**MODIFICATION REQUEST:**  
***Modification to Residential Buildings 4 & 5***  
***61 Mobbs Lane, Epping (former Channel 7 site)***  
***MP 08\_0257 MOD 2***

Director-General's  
Environmental Assessment Report  
Section 75W of the  
*Environmental Planning and Assessment Act 1979*

June 2011

Title Building 4 Ground Floor Plan
Scale 1:100 @ A0
1 2 4 1:100 @ A0

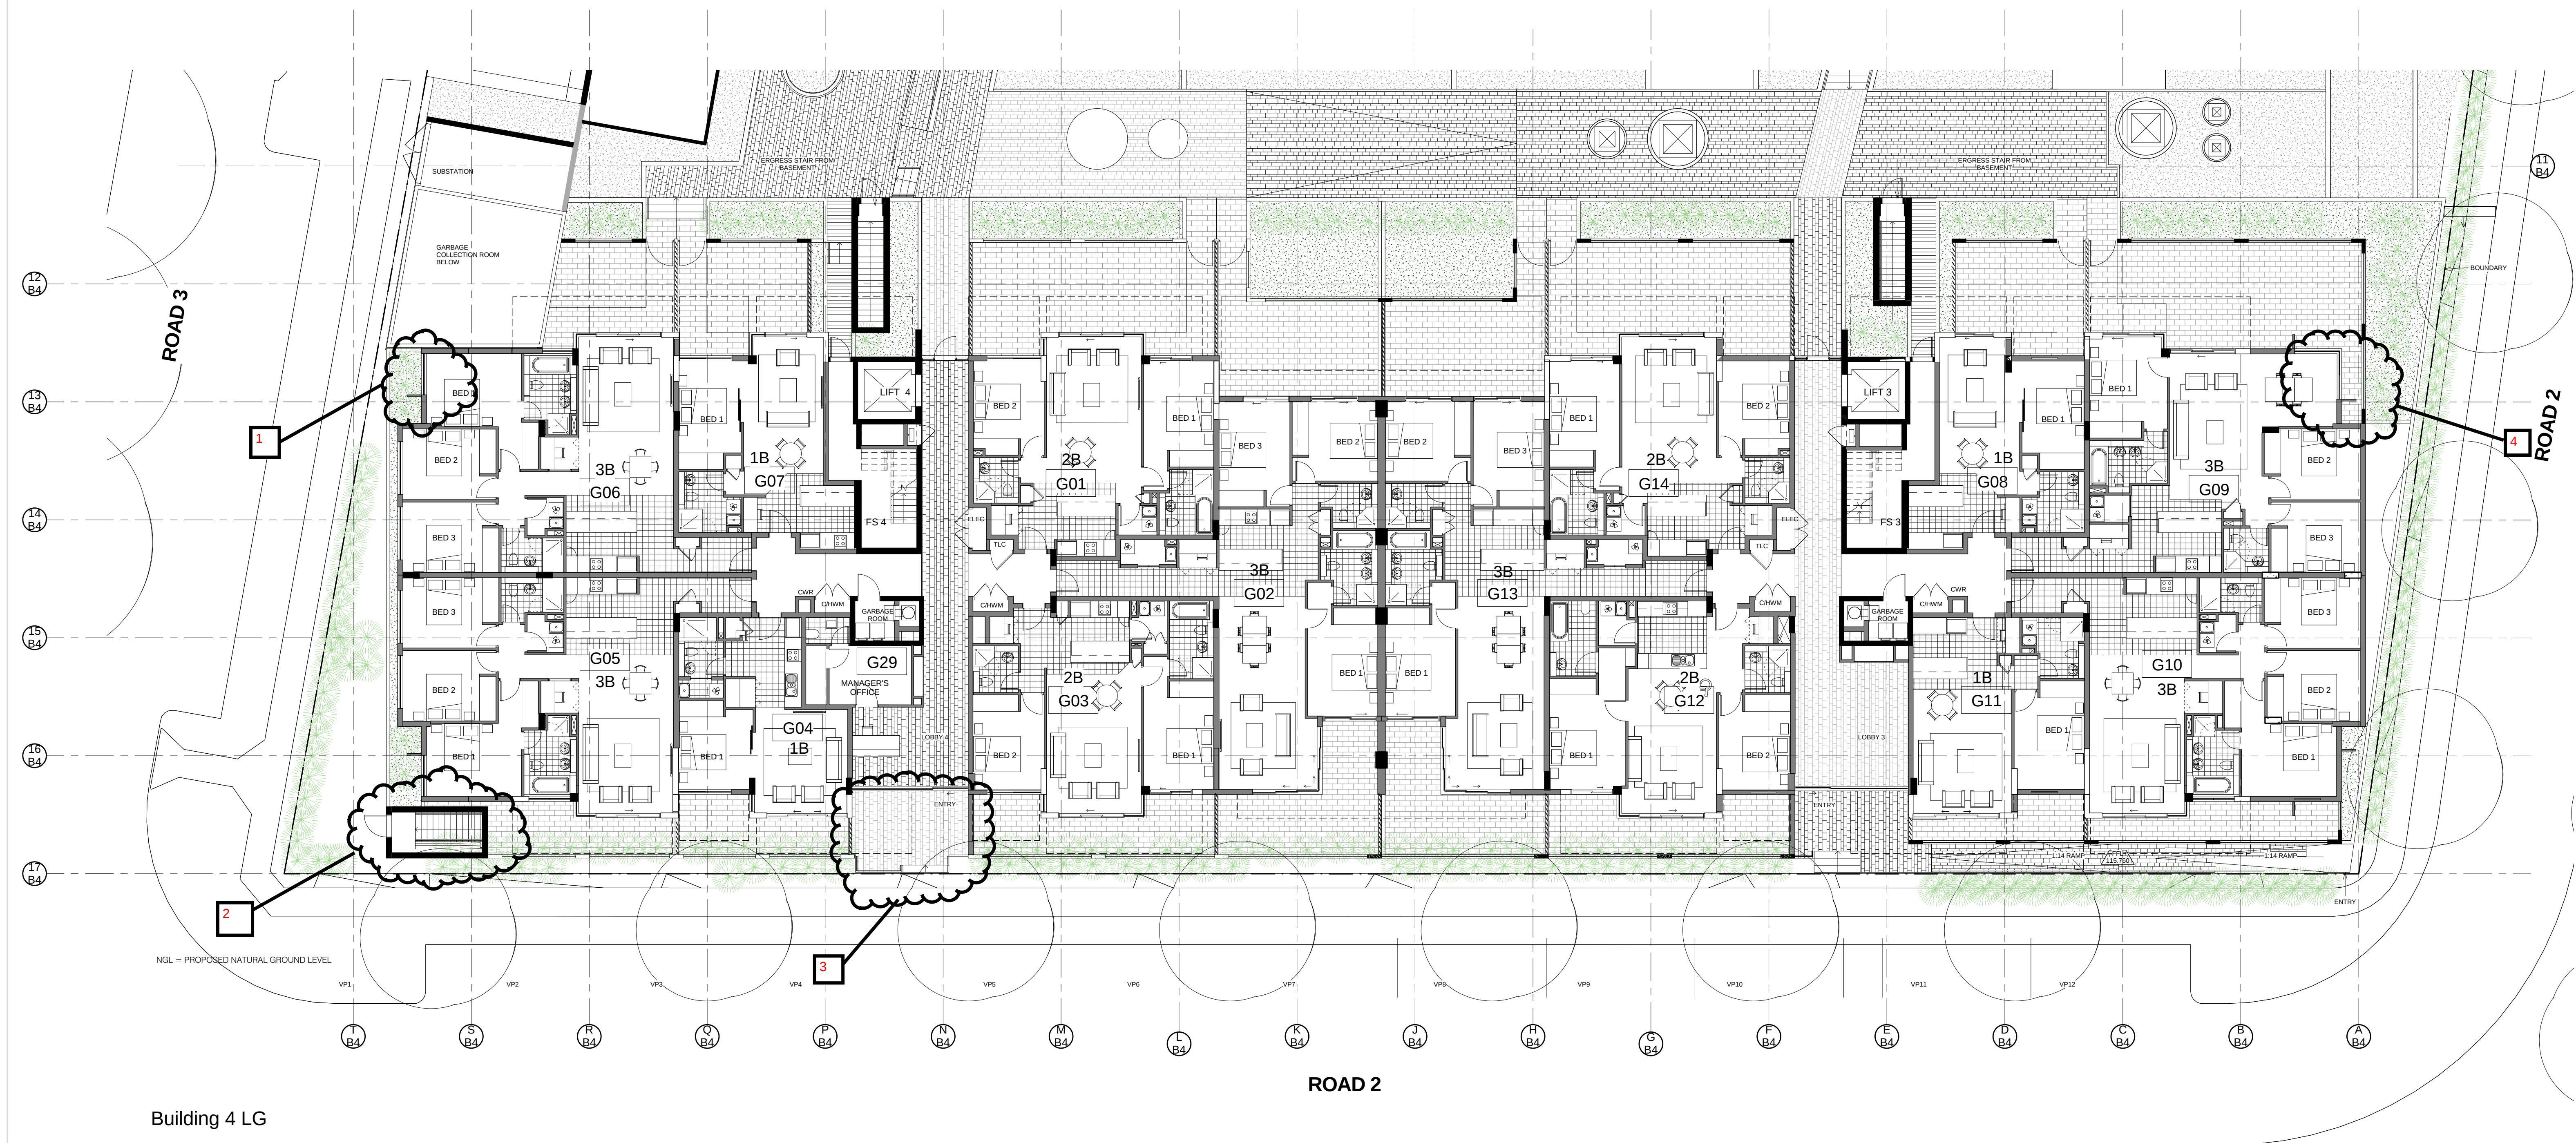
A corner window in two ground floor units in Building 4 will be reduced in size due to modifications to the garbage storage area and basement stairs arrangement. The reduction in size would not have any detrimental impacts on the amenity of residents and the modification is therefore considered acceptable.

Building 4 L6 (Plant)

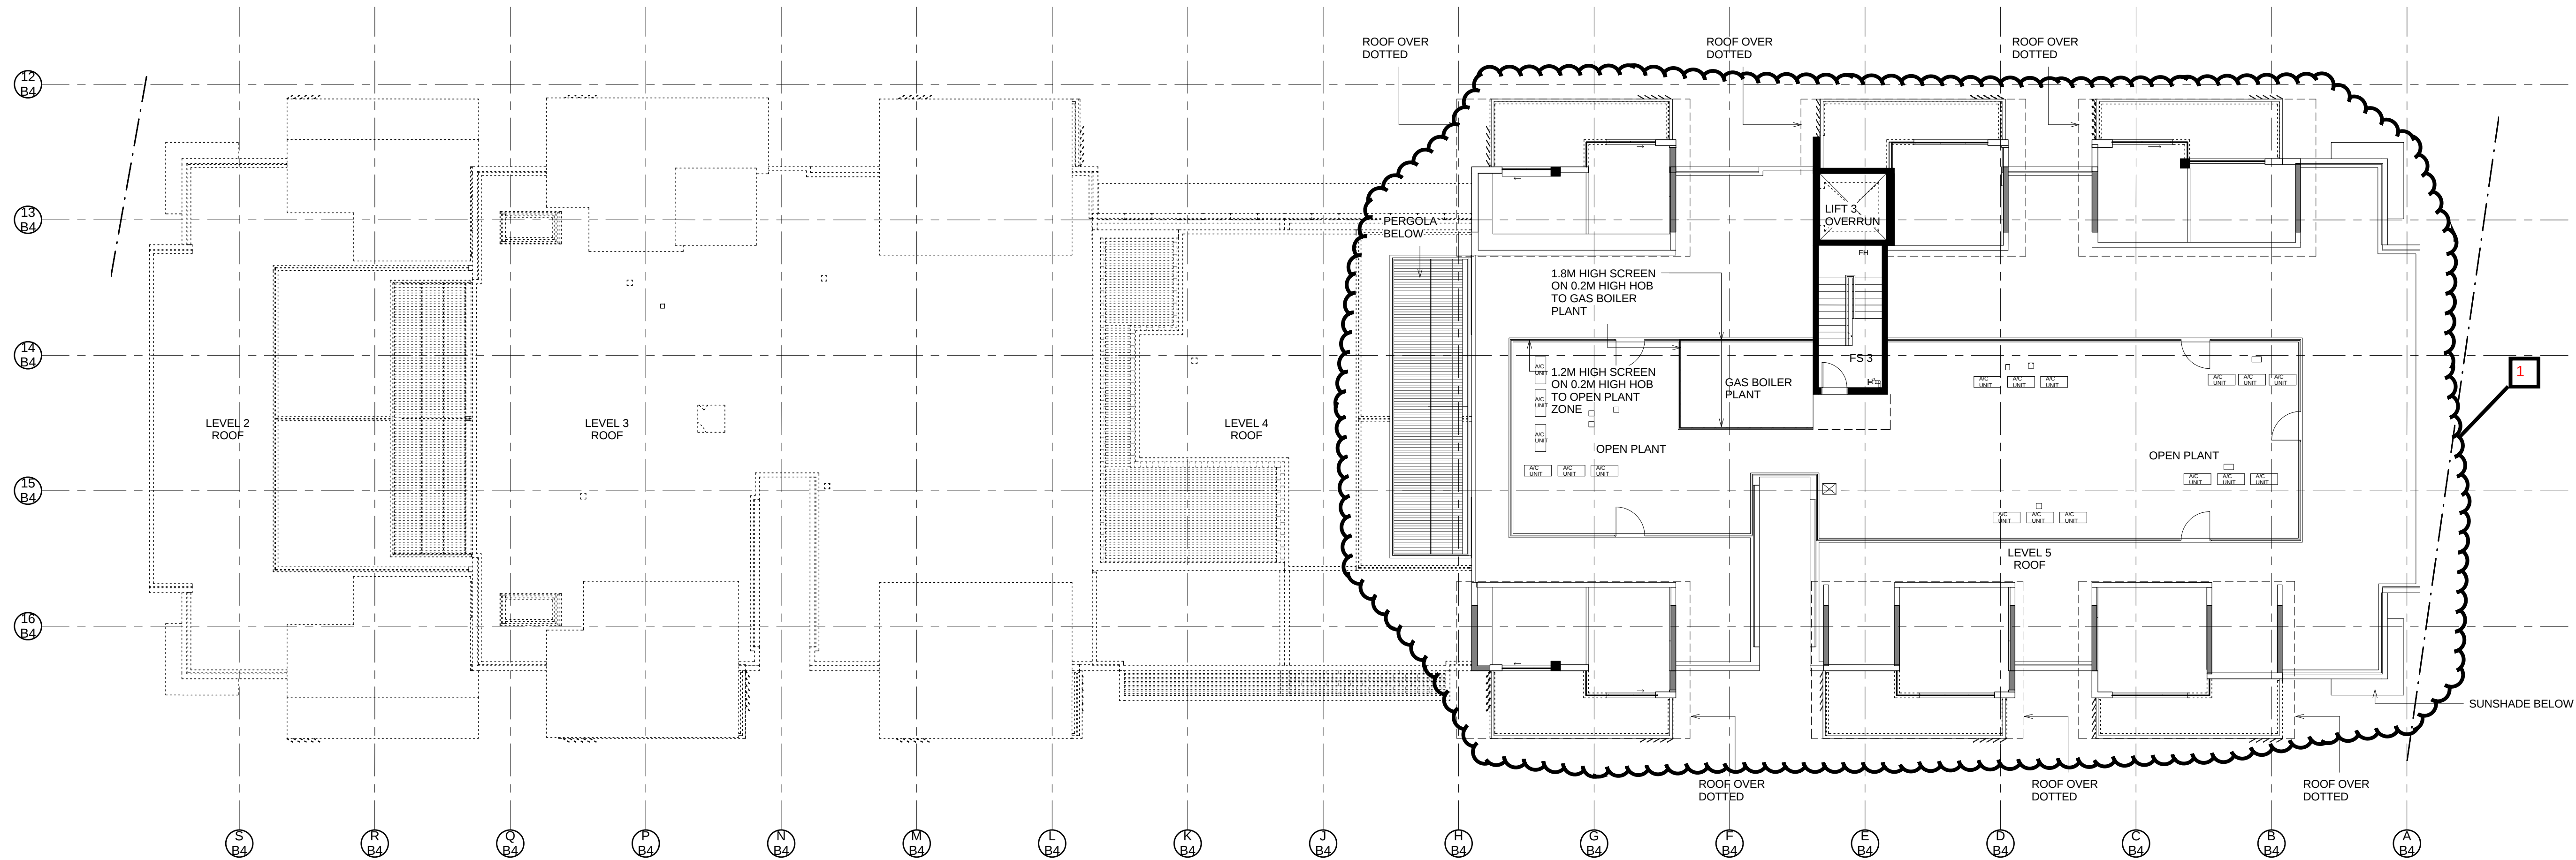
Condition B1 required the screen louvers to the roof level plant to have a maximum height of 1.4m above roof finished floor level. The modification plans illustrate a 1.4m high screen surrounding the roof plant on each building however, also include a 2m high screen surrounding the gas boiler plants to each roof. The gas boiler plants will have a floor area of approximately 15m<sup>2</sup> and will be located centrally on the buildings, therefore reducing their impact when viewed from the surrounding area.

To protect the amenity of surrounding residents a new part has been added to Condition B1. requiring the roof above level 5 on both buildings to remain non-trafficable, except for maintenance purposes.

Building 4 East Elevation

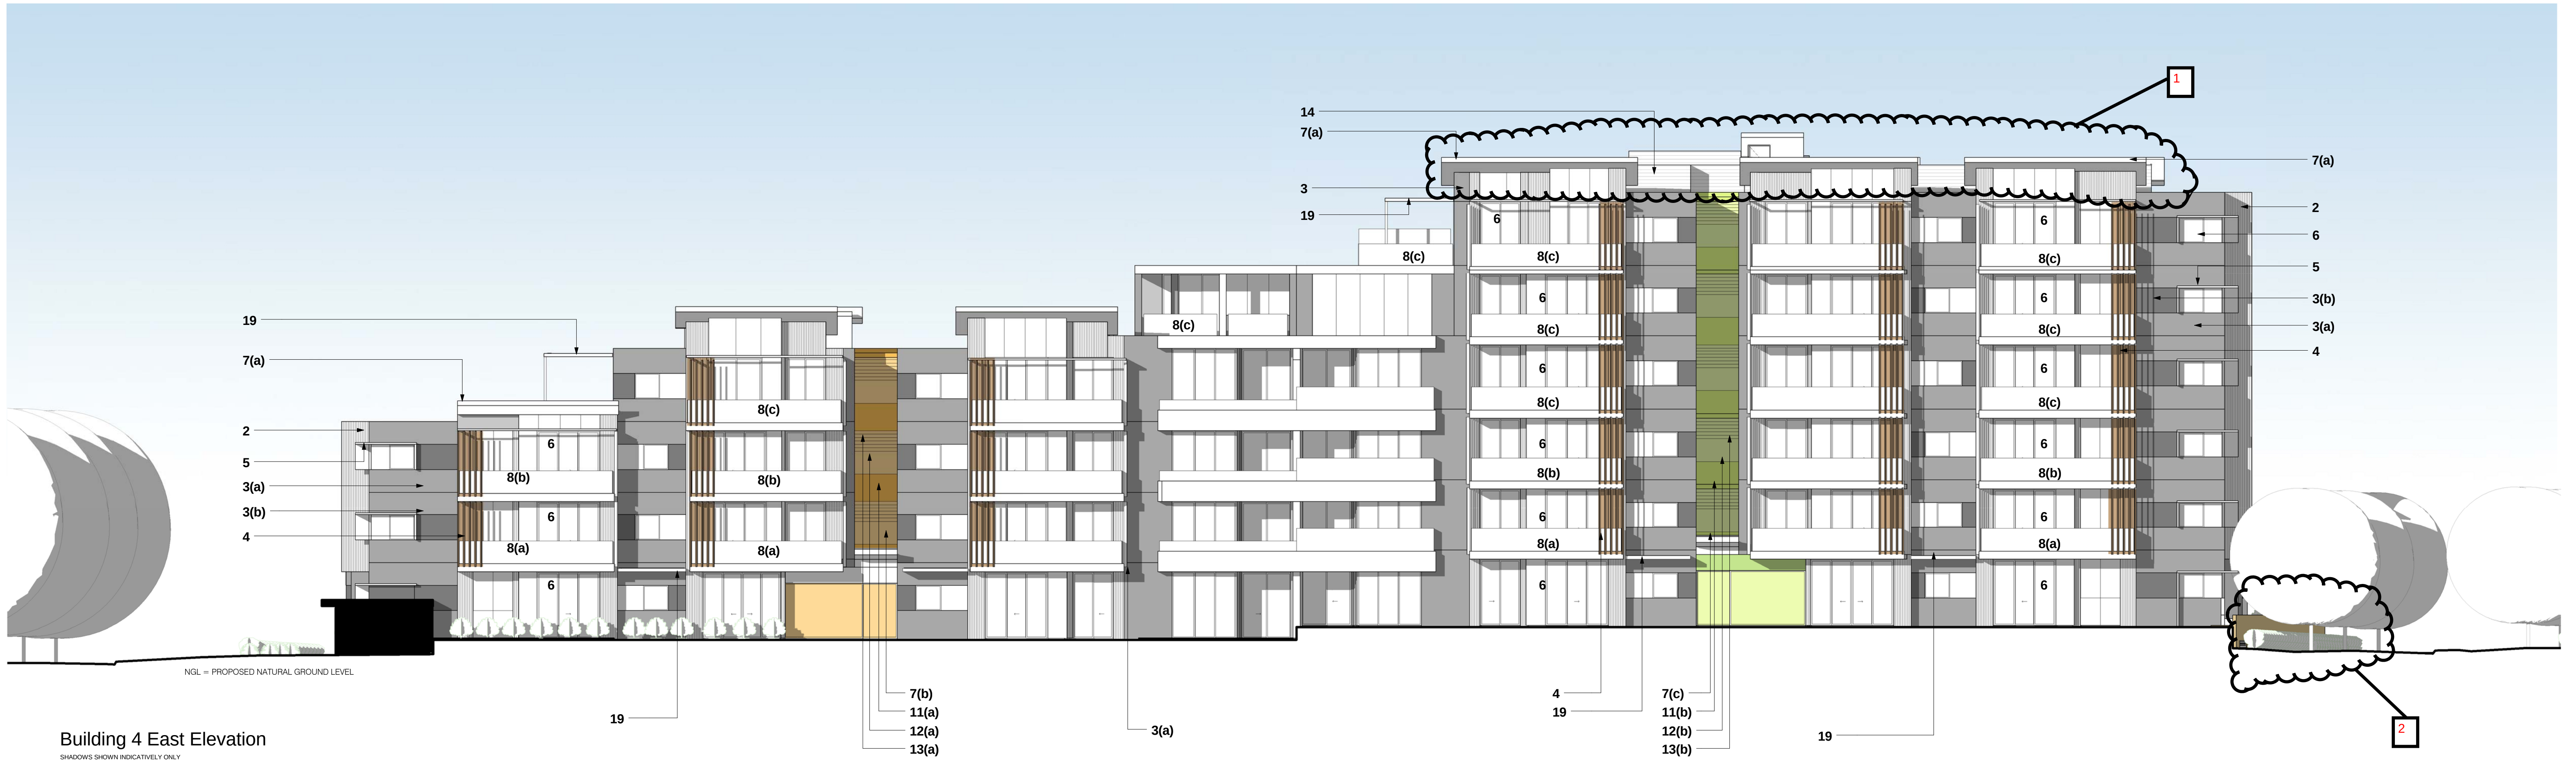
The proposal also seeks consent for additional louvers to side elevations of a number of balconies within both buildings. This will act to provide additional privacy to units. The proposed deletion of side louvers to balconies of the centrally located units within both buildings will not result in any negative impacts as neighbouring areas of private open space will be satisfactorily screened.
